Date: 9<sup>th</sup> December 2024  
Our Ref: 20050384  
Your Ref: EN010135  
Site address: Stonestreet Green Solar

**RE: Application Ref. EN010135 – Solar photovoltaic array plus energy storage with associated infrastructure and grid connection, with a generating capacity greater than 50MW.**

This letter is written in response to the Stone Street Green Solar Written Representations request which are due on the 9<sup>th</sup> of December 2024. Kent Wildlife Trust's Written Representations expand on the comments made during the Relevant Representations, which were submitted in September 2024. Kent Wildlife Trust's remit includes impacts to biodiversity within Kent. We have reviewed relevant documents submitted within the DCO against national and local legislation and policy. A summary of our main concerns is described in the box below, with more detailed comments in the main body of the letter.

Produced:	Checked:	Date:	Version:
RC	Quod	May 2024	01

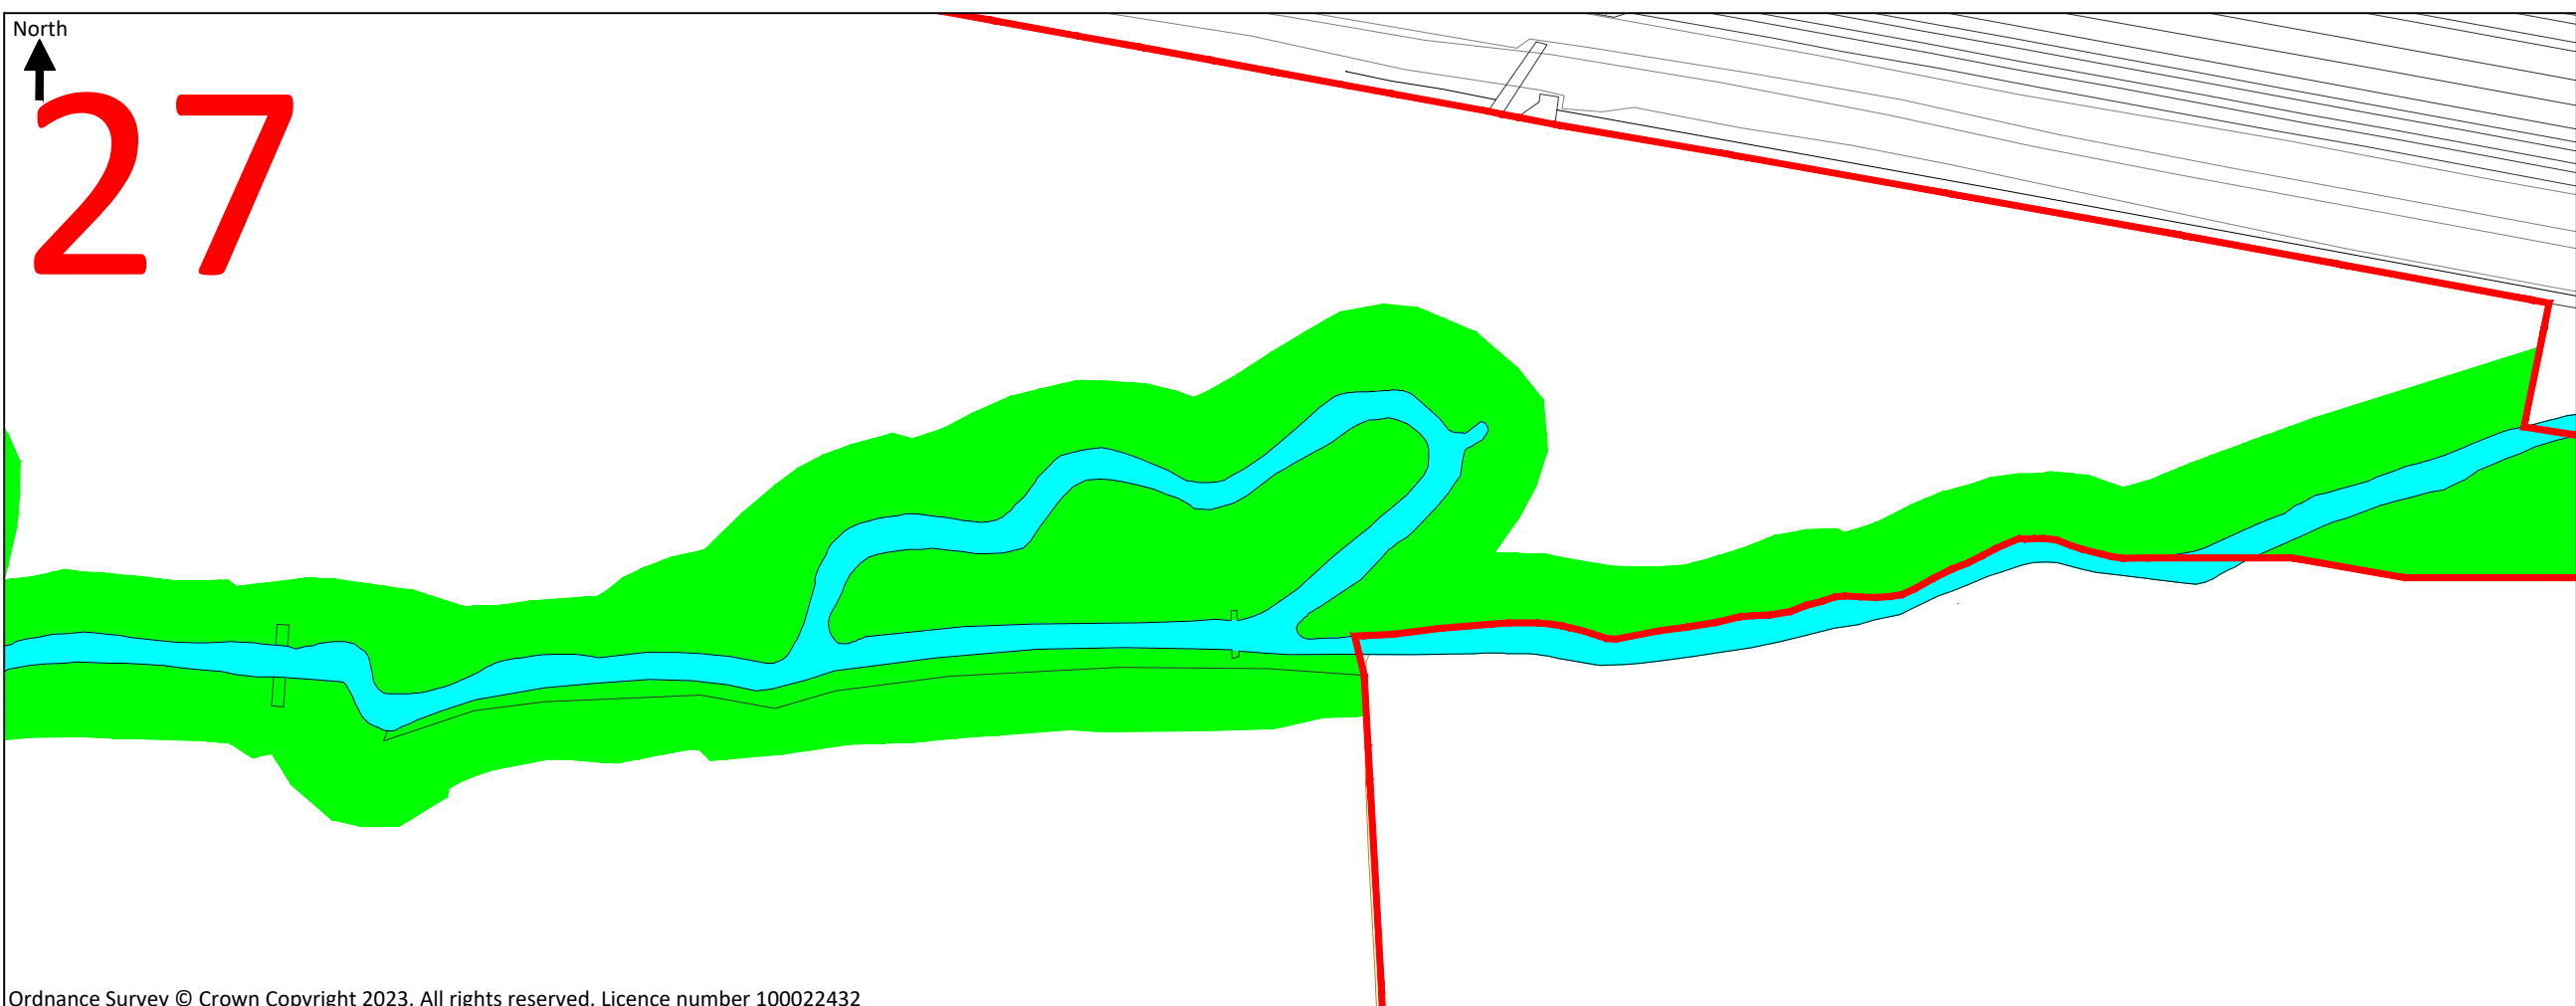
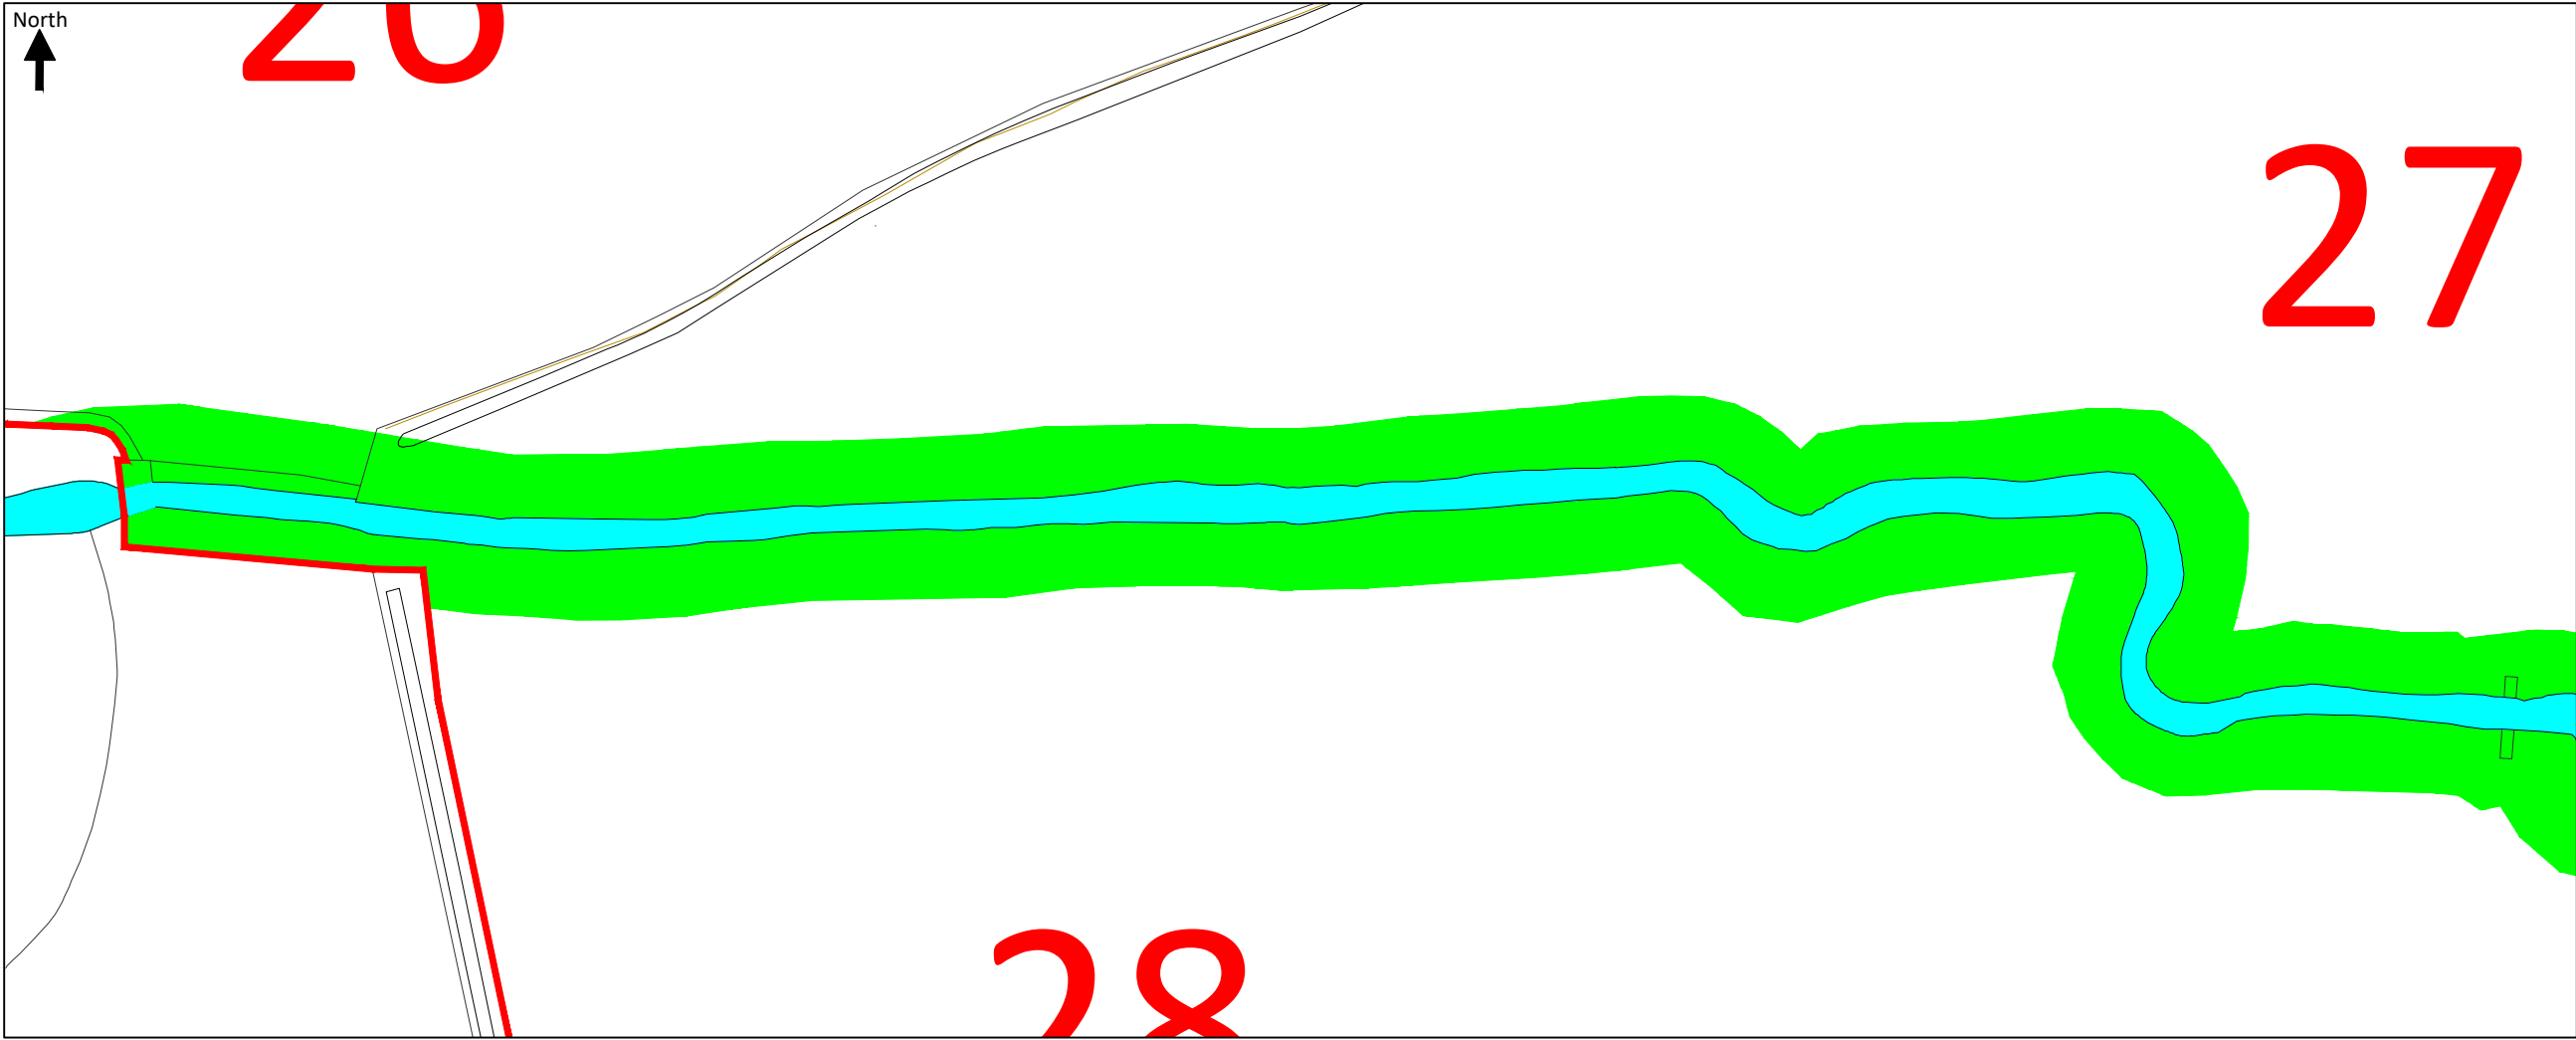
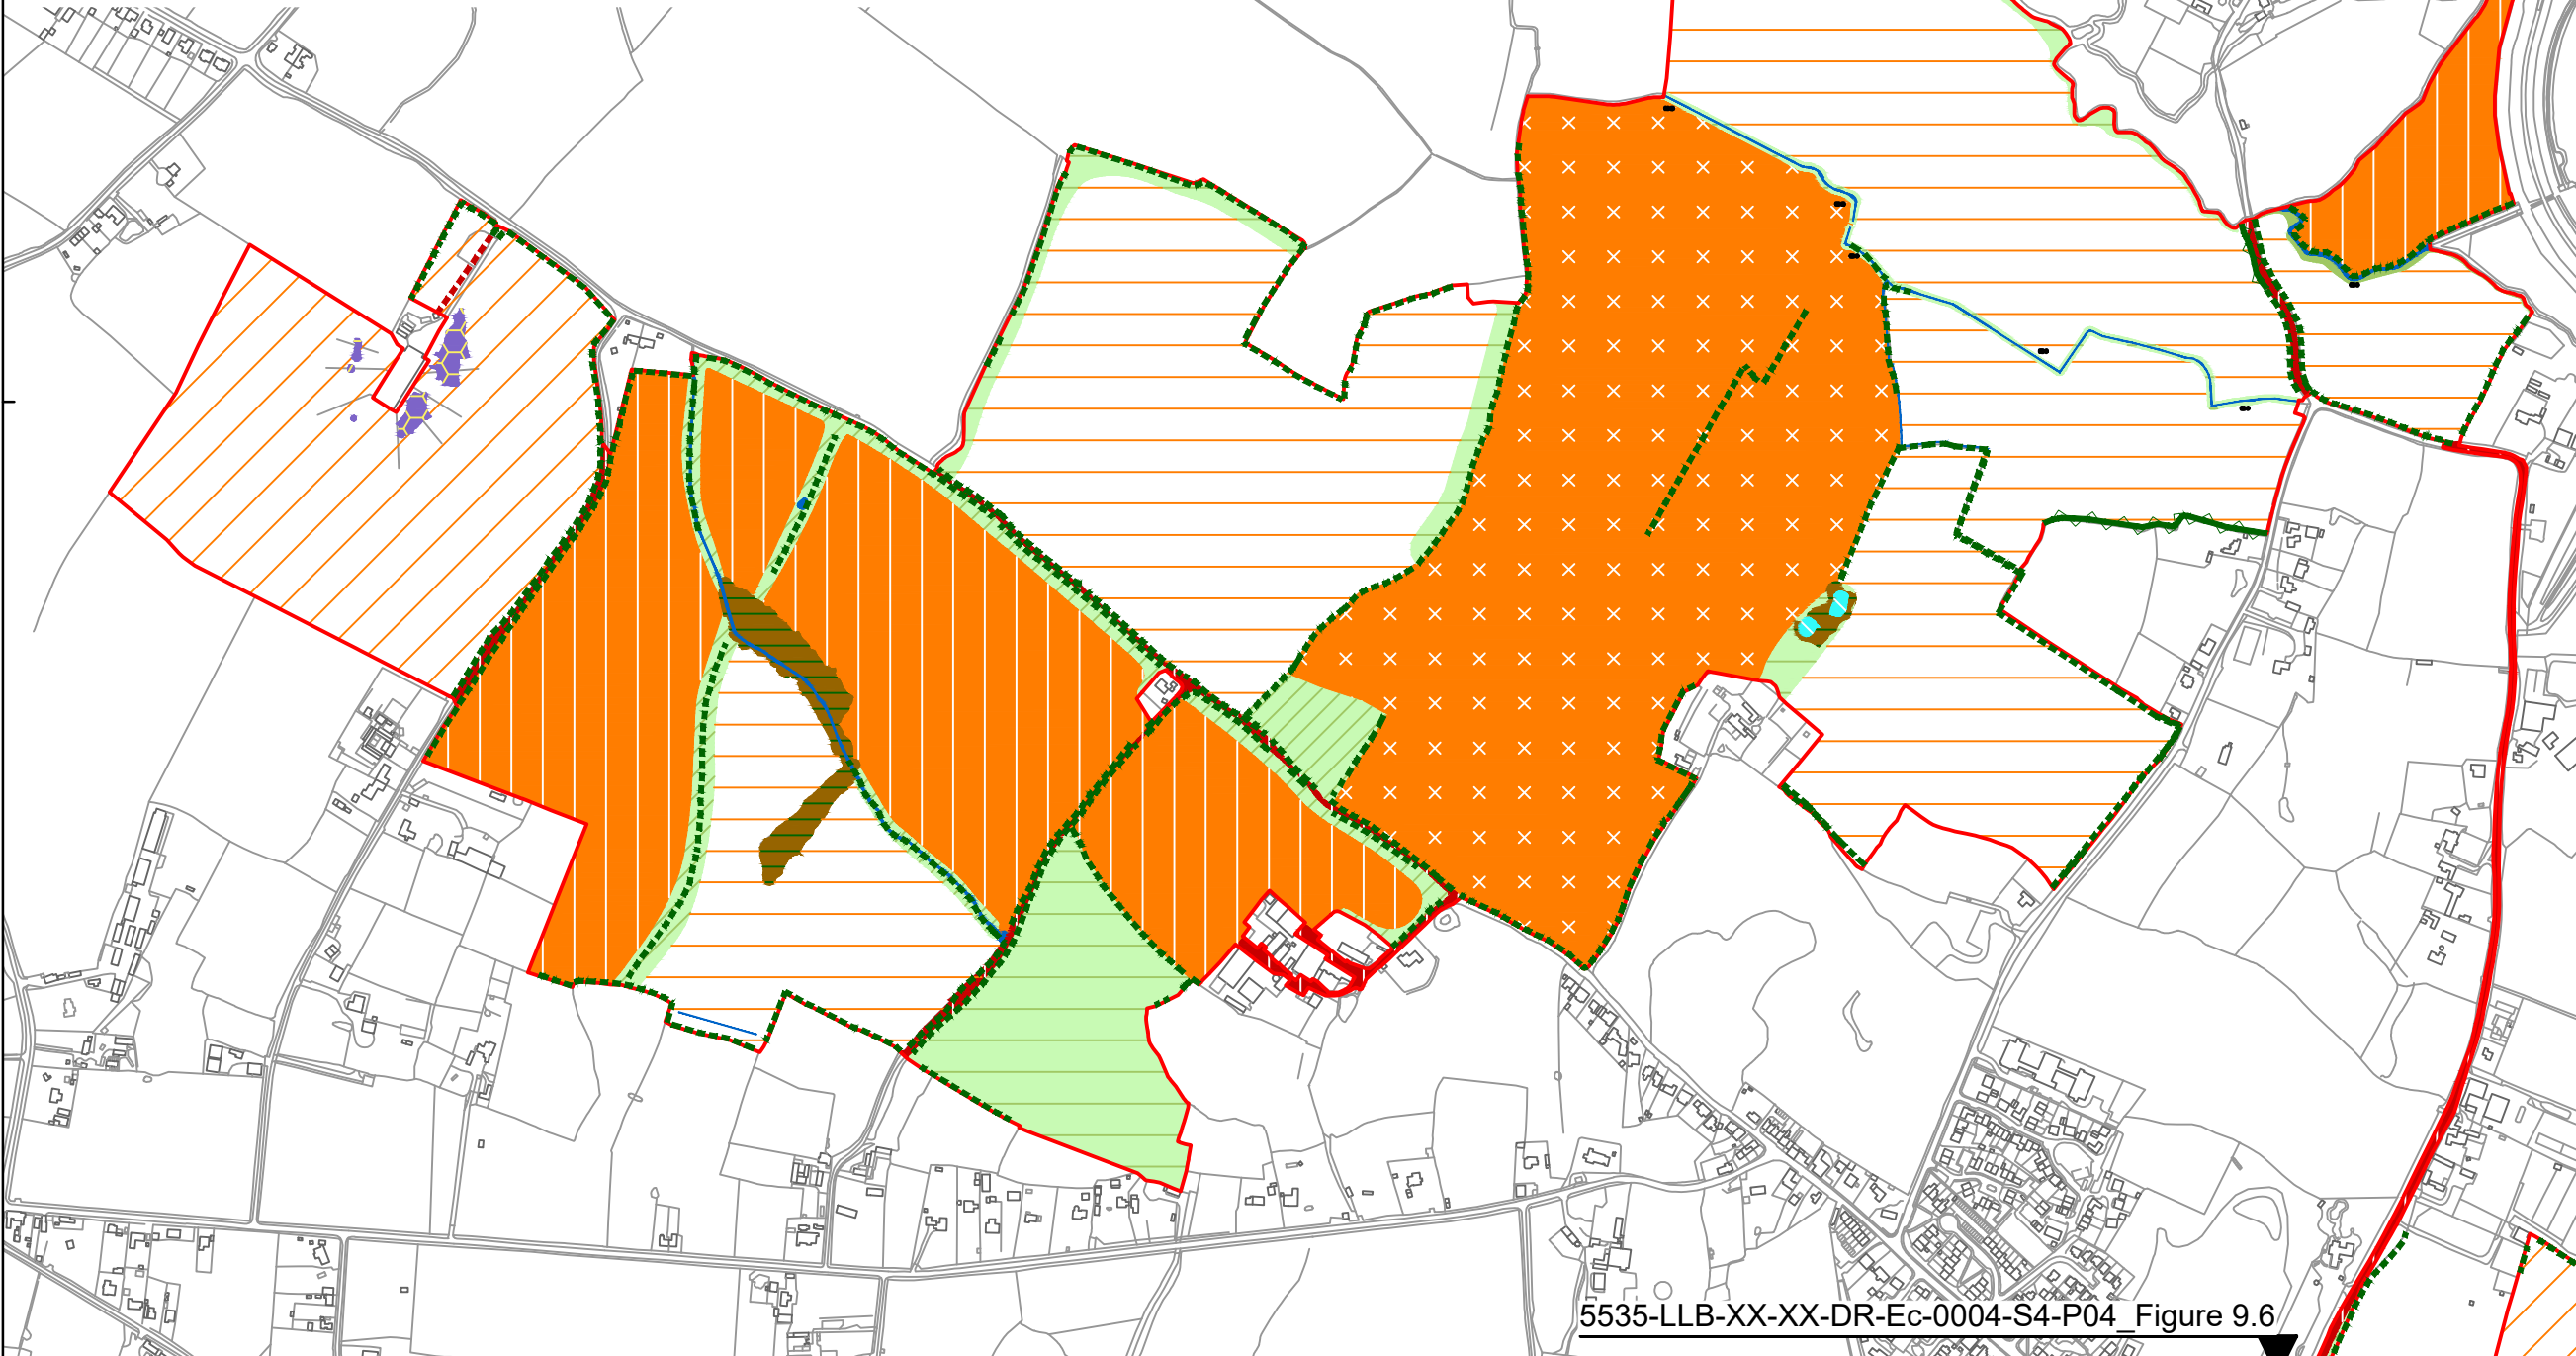
KWT wish to raise concerns about the proposed use of horizontal directional drilling (HDD) under the East Stour River. We have been told as part of the Sea Link project, which is currently going through the NSIP process, that it is not possible to carry out HDD under the Stour. Security is therefore needed that this process can be achieved given the conflicting lines from different projects. Sufficient information also needs to be provided on what alternative approaches will be considered if HDD is not possible along with full assessments of the ecological impacts of these alternative options. In addition, no measures have been put in place around what remedial action will be taken in the event that there is an unexpected issue while HDD is being undertaken.

Insufficient information has been provided to clearly establish that the proposed sites for temporary bridges over the East Stour River are suitable in terms of the condition of the riverbanks. We are therefore concerned about the risks that such an approach poses to the integrity of the riverbanks and the ongoing protection and enhancement of the river.

Limited information has been provided on the proposed foul water collection and treatment process as a means of removing potential impacts to the East Stour River from surface water flooding. We are concerned about the effectiveness of this approach and the biodiversity impacts of implementing this system prior to the commencement of development.
